Highways England Planning Response (HEPR 16-01)

Formal Recommendation to an Application for Planning Permission

Council's Reference: A/40/18/OUT

Location: Land North of Water Lane, Angmering.

TITLE: PROPOSED IMPROVEMENT SCHEME TO A280 / A27 / TITNORE LANE ROUNDABOUT			
PROJECT: LAND SOUTH OF WATER LANE, ANGMERING		CLIENT: RYDON HOMES, GLEESON DEVELOPMENTS LTD

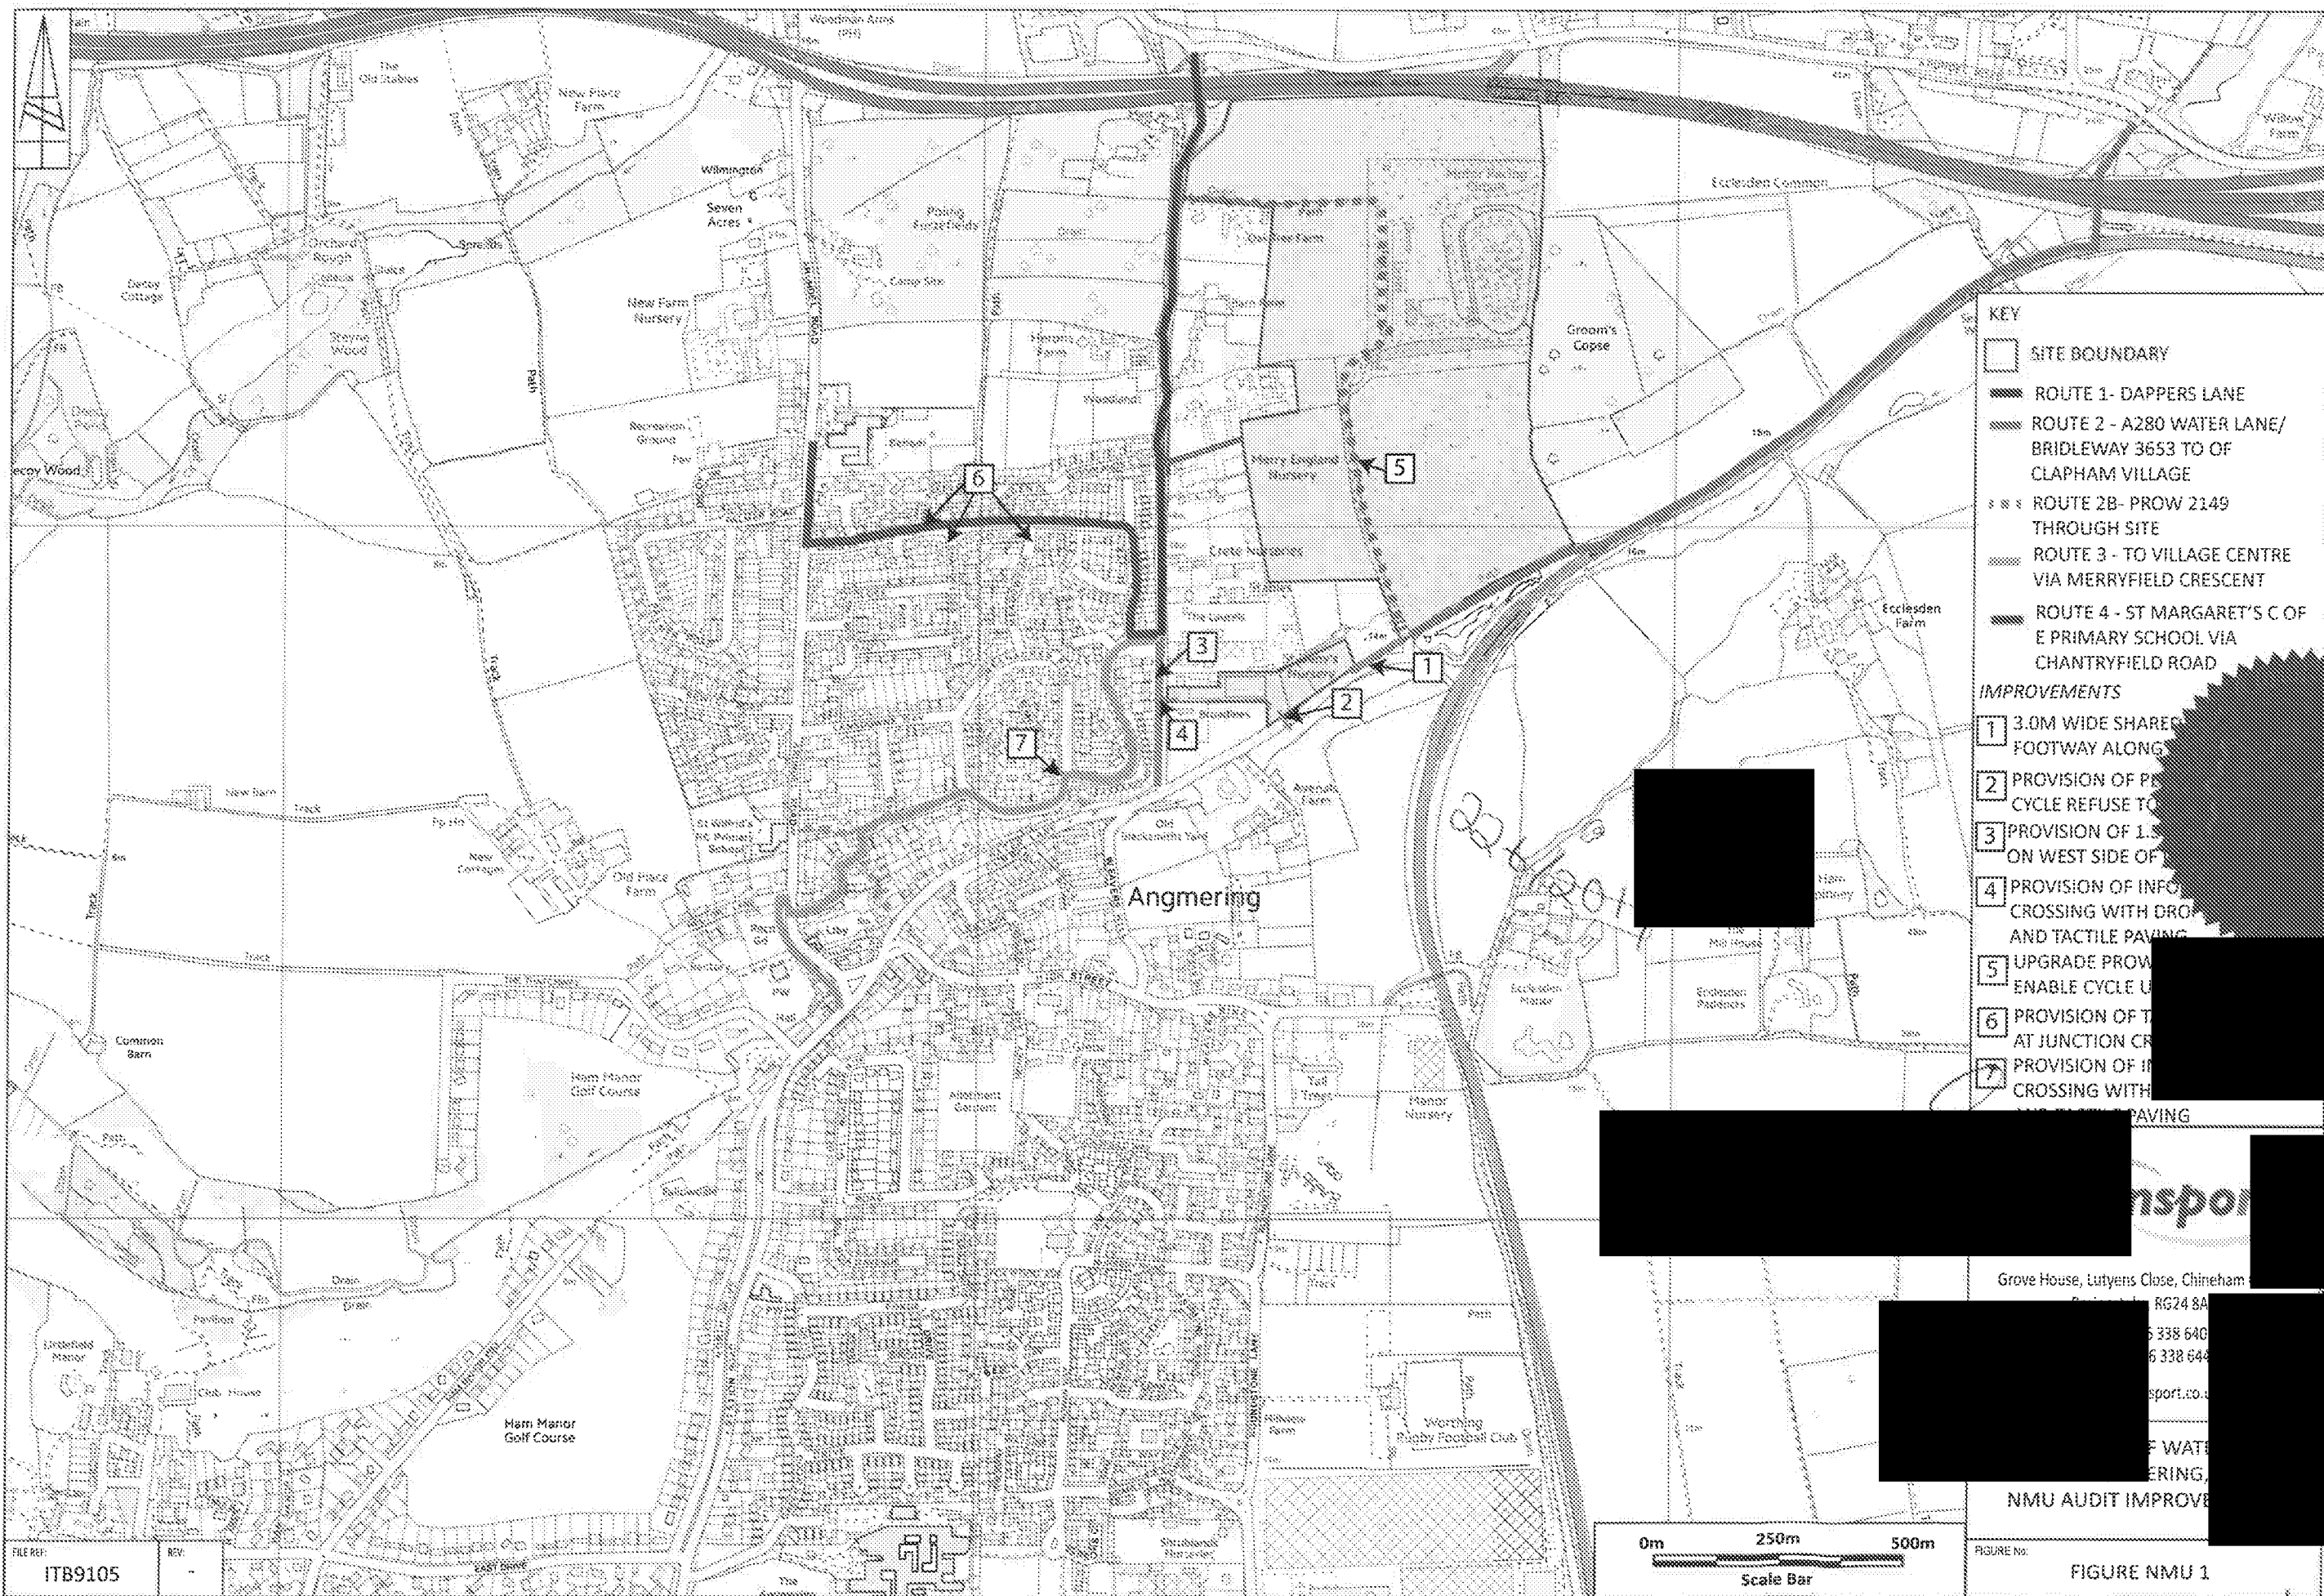
- 1) No part of the development hereby permitted shall be commenced until completion and opening to use of the highway improvement works as shown on i-Transport's drawing number "ITB9105-GA-024 – *Proposed Improvement Scheme to A280/A27/Titnore Lane Roundabout*" shown (or such other scheme of works substantially to the same effect, as may be approved in writing by the local planning authority (who shall consult with Highways England)), including any necessary transfer of lands to enable the construction and maintenance of the scheme.

Reason: The modifications have been proposed to provide sufficient capacity at the A280 / A27 / Titnore Lane Junction. This is to ensure that the A27 Trunk Road continues to be an effective part of the national system of routes for through traffic in accordance with section 10 of the Highways Act 1980 and to satisfy the reasonable requirements of road safety.
